**DELEGATED DECISION FOR APPLICATION FOR CERTIFICATE OF
LAWFUL DEVELOPMENT**

Reference no.: 2024/CL/90982/E

Site: Ashlar House, 27, Balk Lane, Upper Cumberworth,
Huddersfield, HD8 8NZ

Description: Certificate of lawfulness for proposed installation of
solar panels (within a Conservation Area)

Plan Reference Number: TQRQM24096121150208

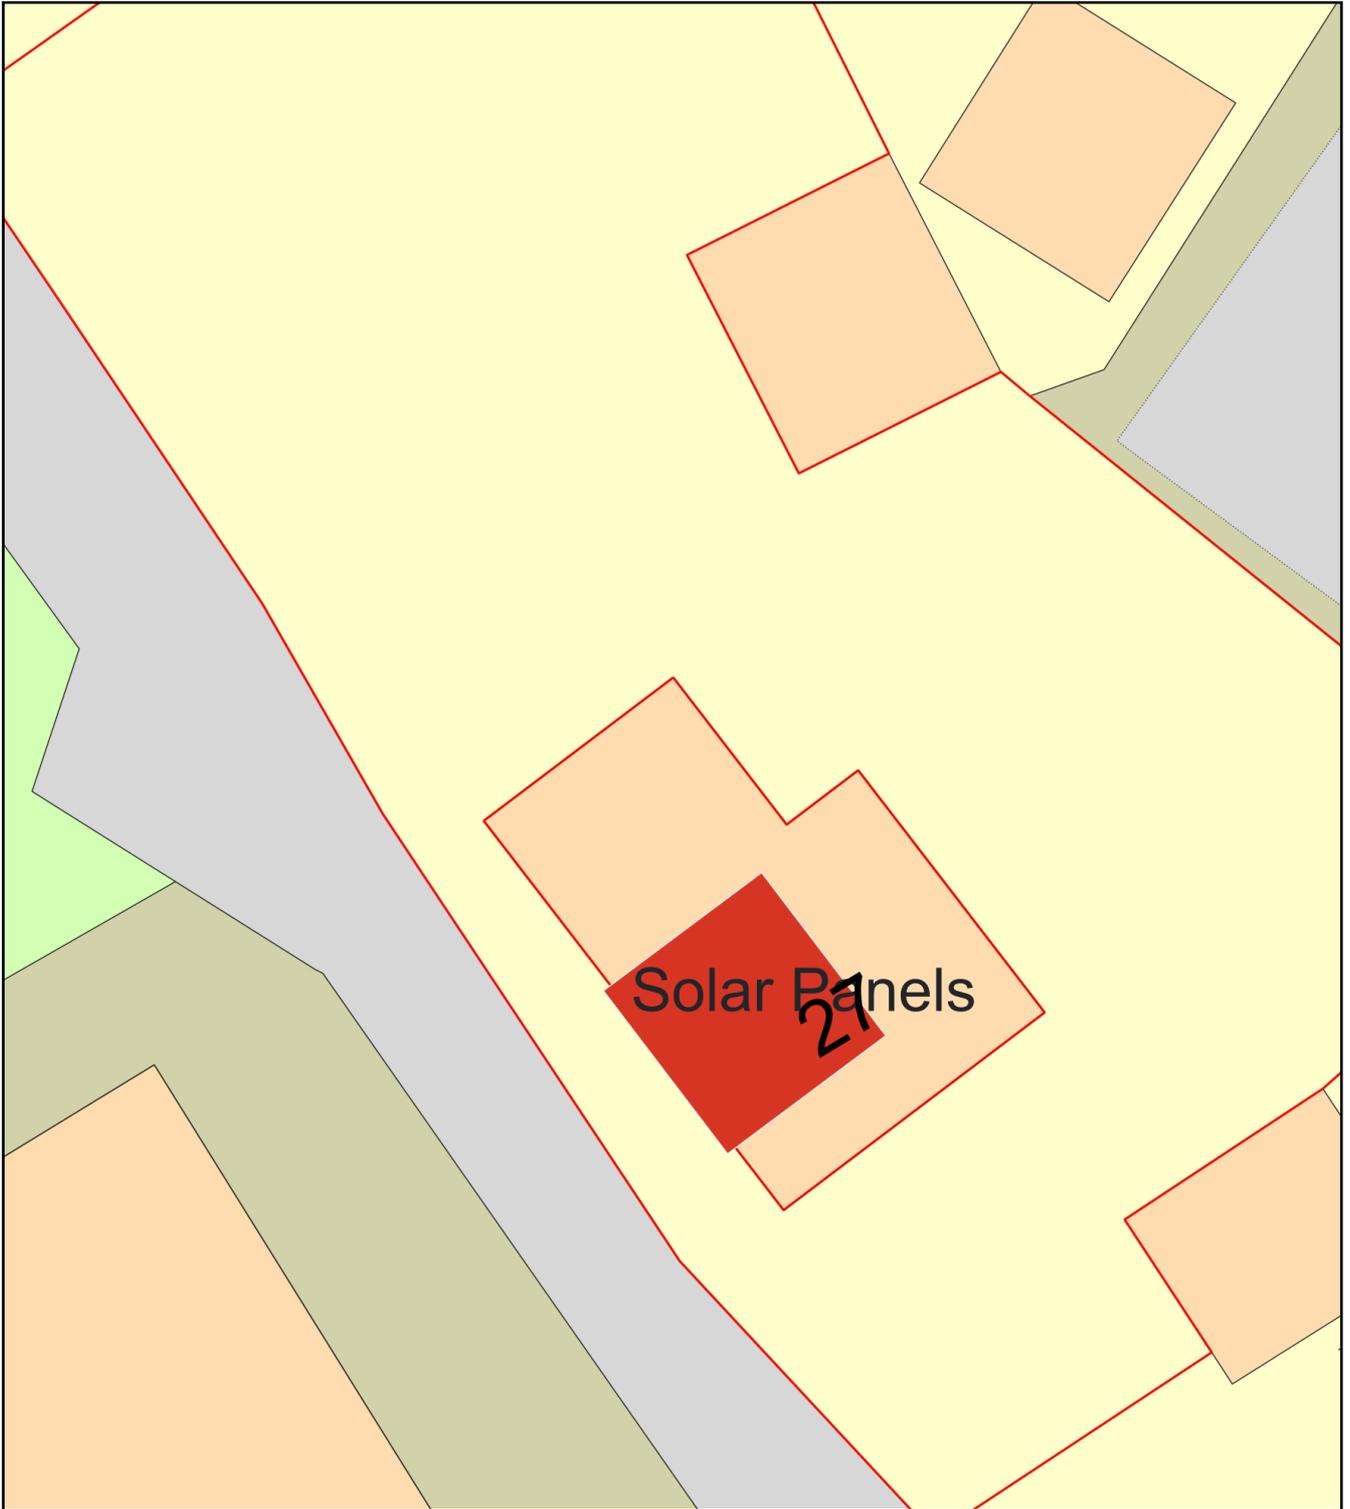
Solar panels are proposed on the rear (west) elevation which would have a length of 5m and a width of 5.3m. Information has been provided by the applicant stating that roof tiles shall be removed where necessary in order to allow the solar panels to sit flush with the roof plane.

Comment: *the applicant dwelling features a pitched roof. Information has been provided stating that roof tiles would be removed where necessary with the aim*

of installing the panels flush with the roof plane. As such, the proposed panels would not be higher than the highest part of the roof or protrude more than 0.2m beyond the roof plane. The site is located within a conservation area; however, while the panels will front a public right of way (highway) the panels are proposed on the roof and not a wall.
